# Copse Edge Avenue Residents Association

## **Objection letter from CEARA to 21/01287/FUL - 81 College Road**

I write on behalf of the Copse Edge Avenue Residents Association (CEARA) to object to the planning application referenced 21/01287/FUL. CEARA is made up of nearly 50 households. Although the plot is currently in the garden of a College Road house, the new dwelling would be in Copse Edge Avenue, a private unadopted road. The relevant planning policies and objection arguments are set out below.

TITLE:
Tree survey_exisiting

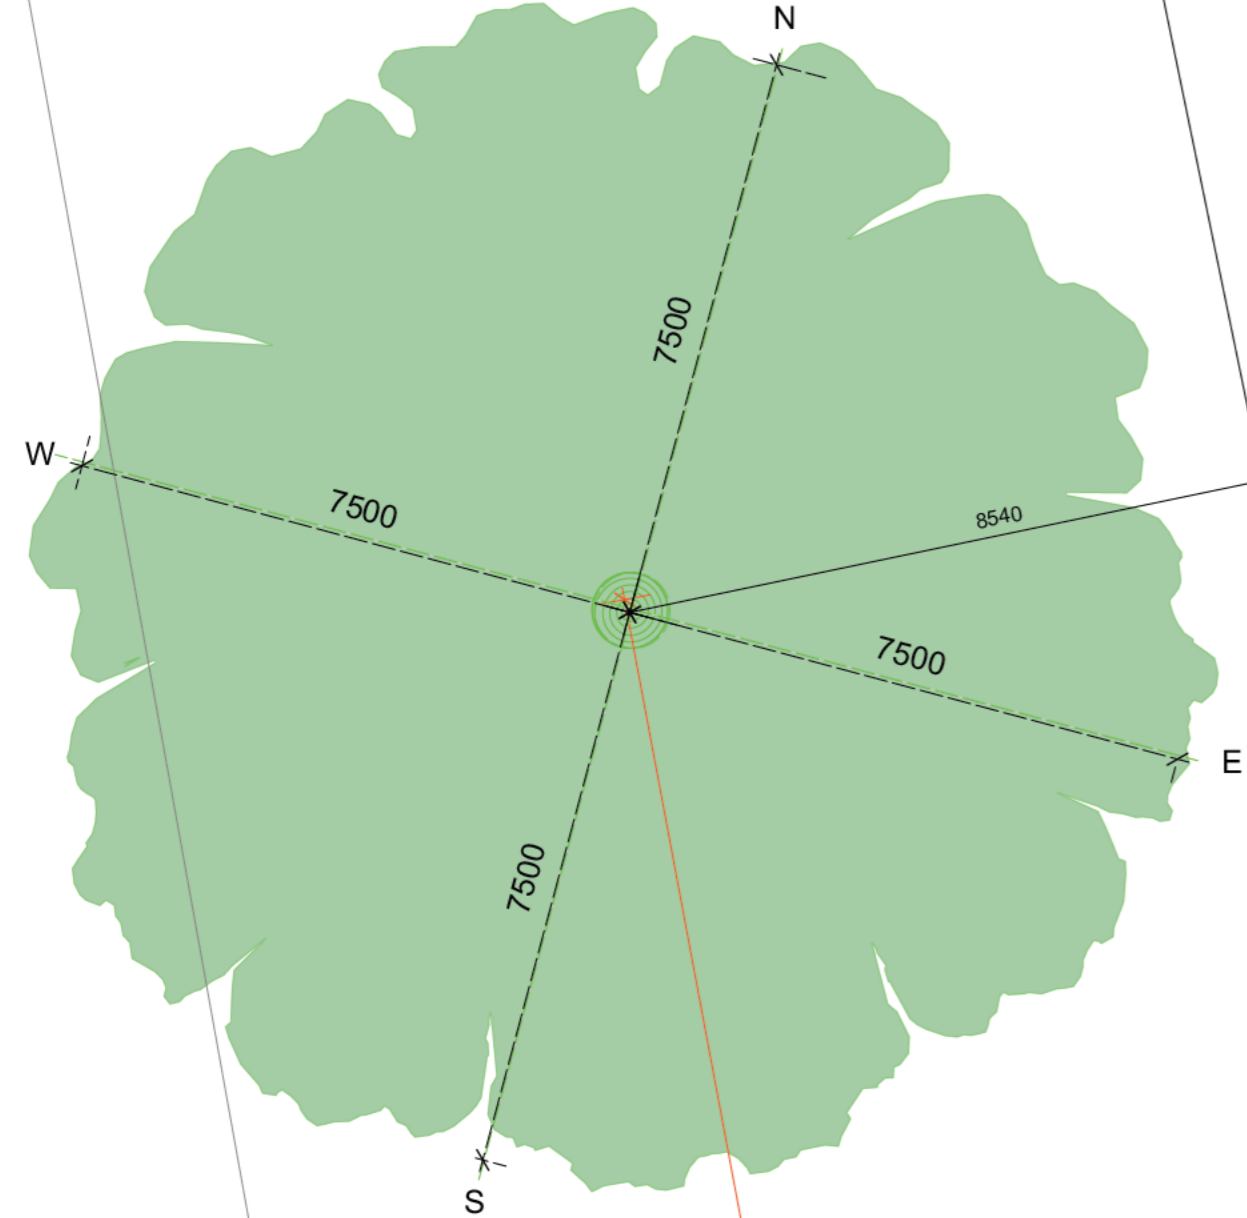
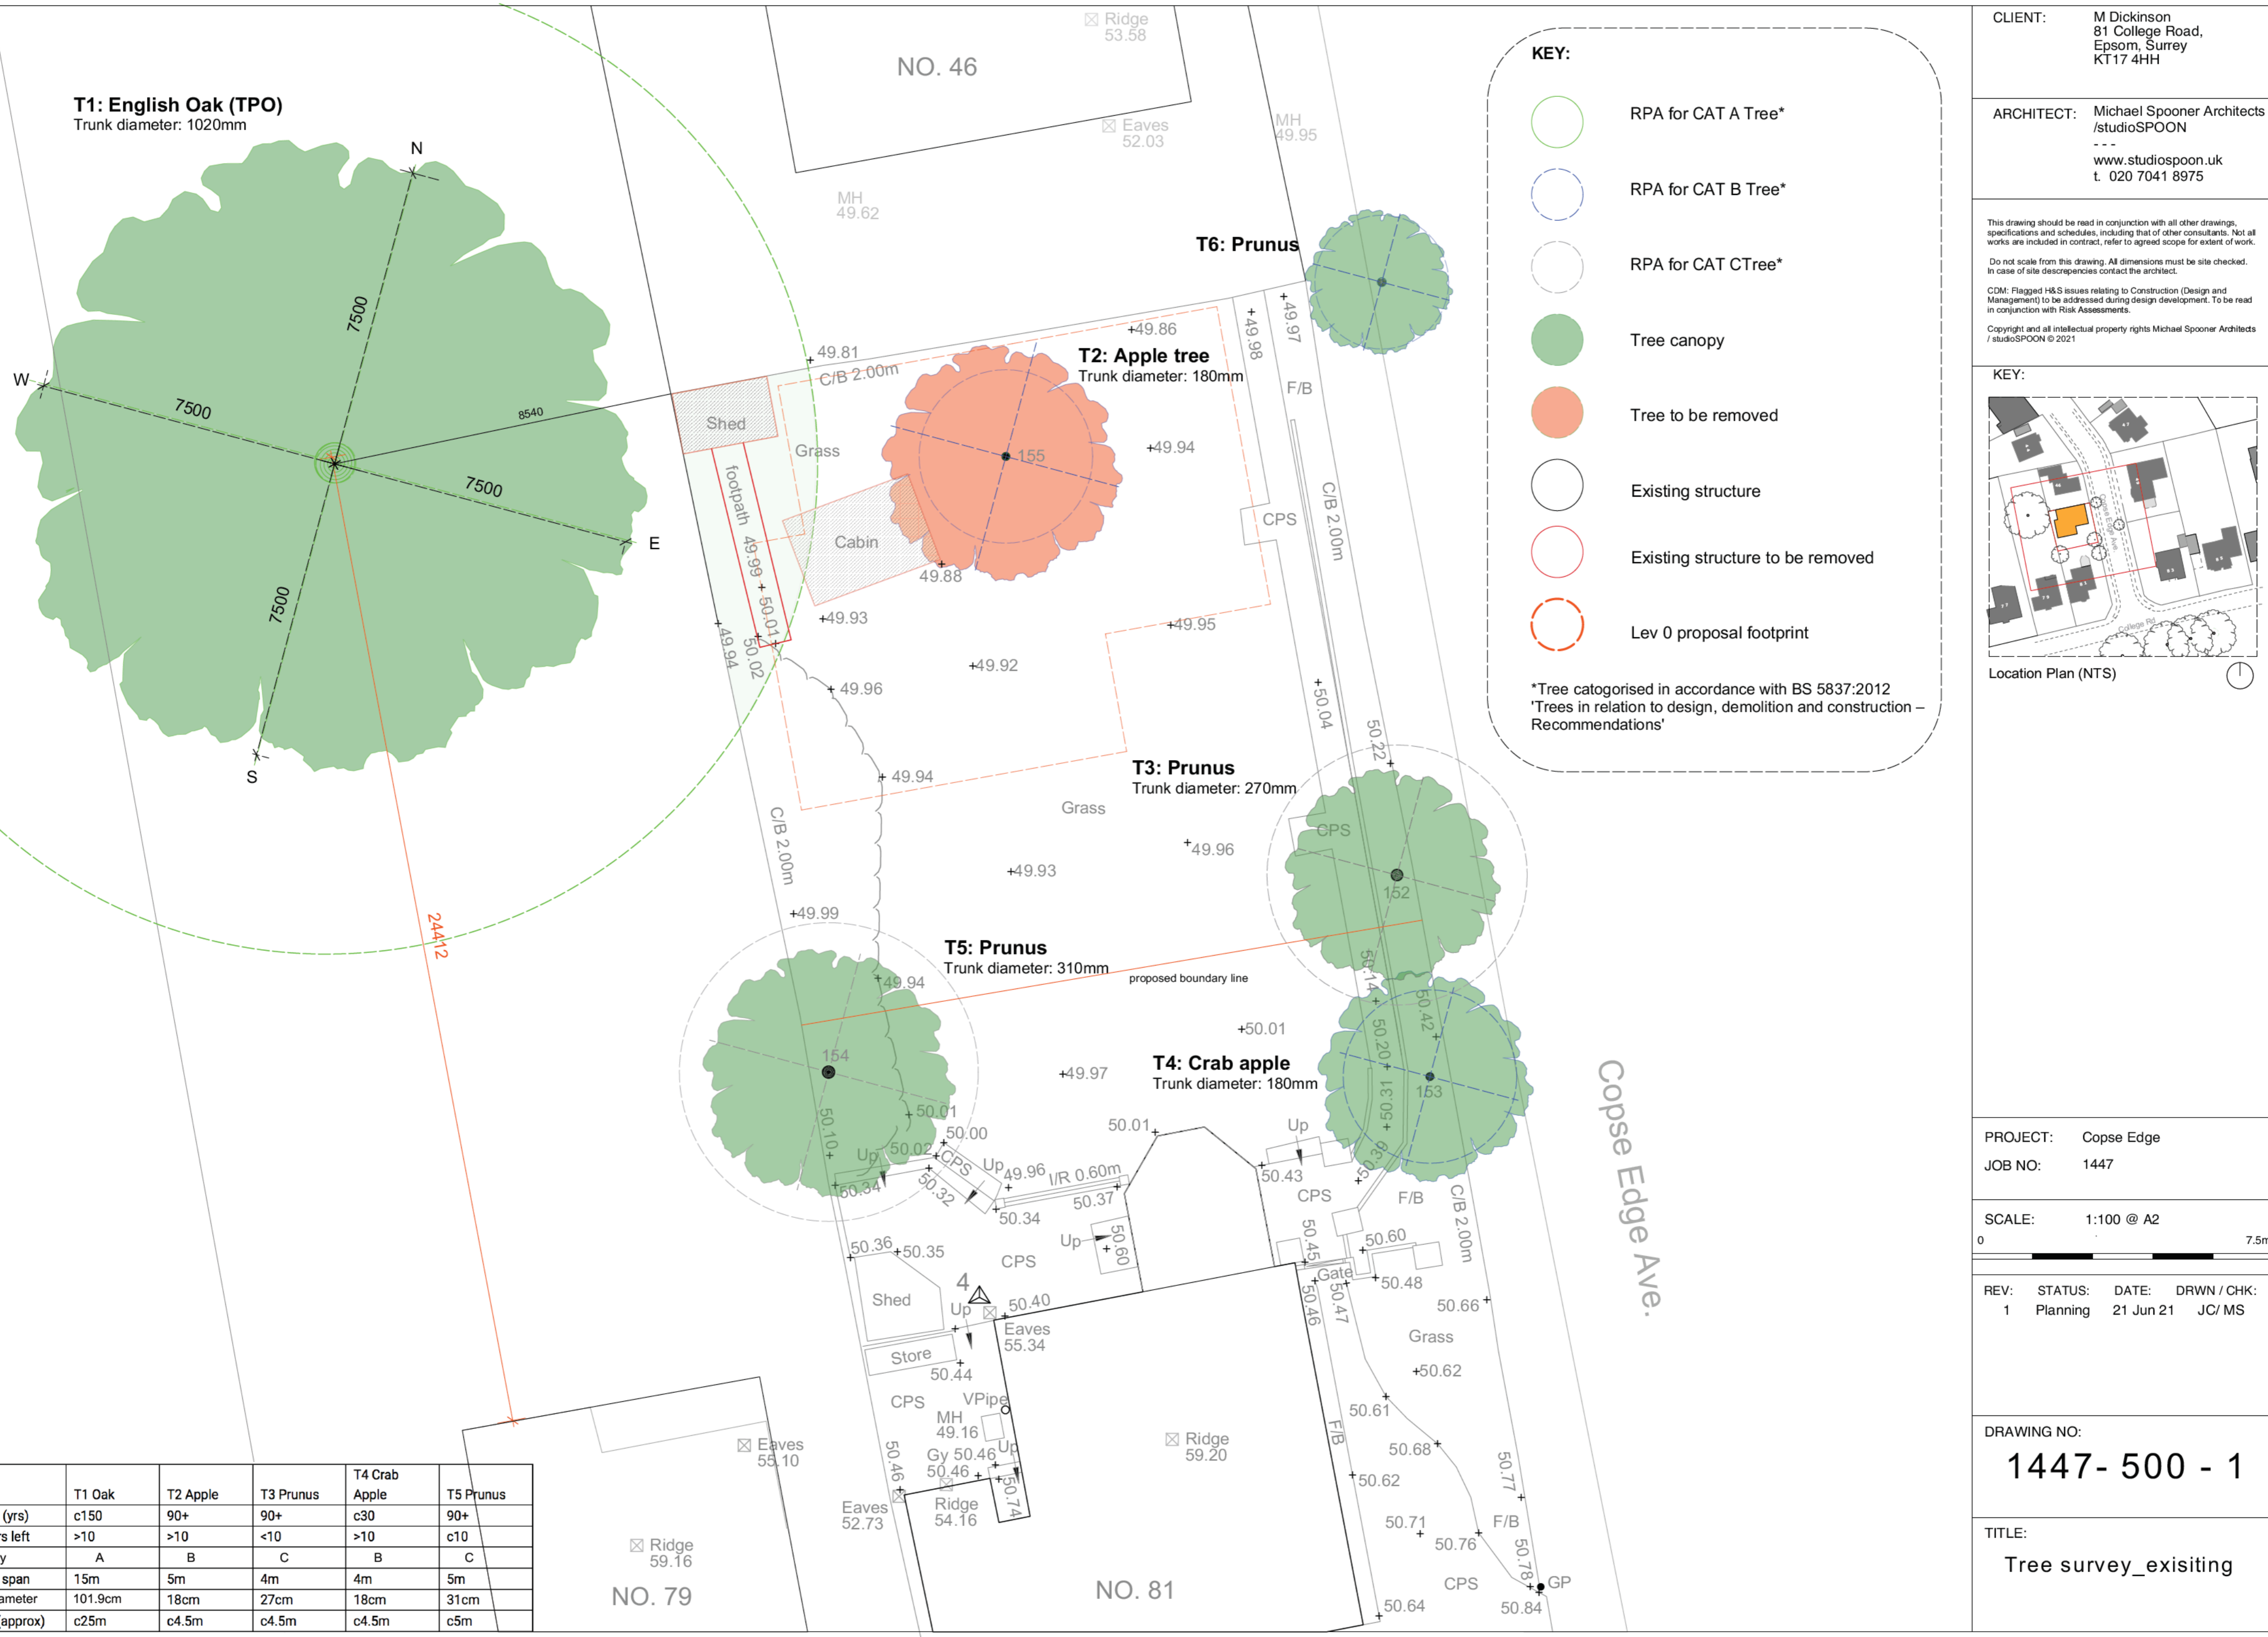
Two main contraventions here: 1. A mature apple tree at T2 will be removed and not replaced as there is no space. The footprint of the dwelling takes over most of the plot. 2. The foundations of the proposed dwelling will impinge on the 12m+ radius of the Root Protection Area of the mature oak tree at #79 College Road. As the soil levels are shallow here due to the chalk substrate, it is very likely that the oak's roots will be severely damaged over a 45 degree segment of the RPA.

The loss of trees represents 50% of those on the existing plot, so significant. No other tree or hedgerow planting is suggested as there is little plot space not taken up by building or access corridors.
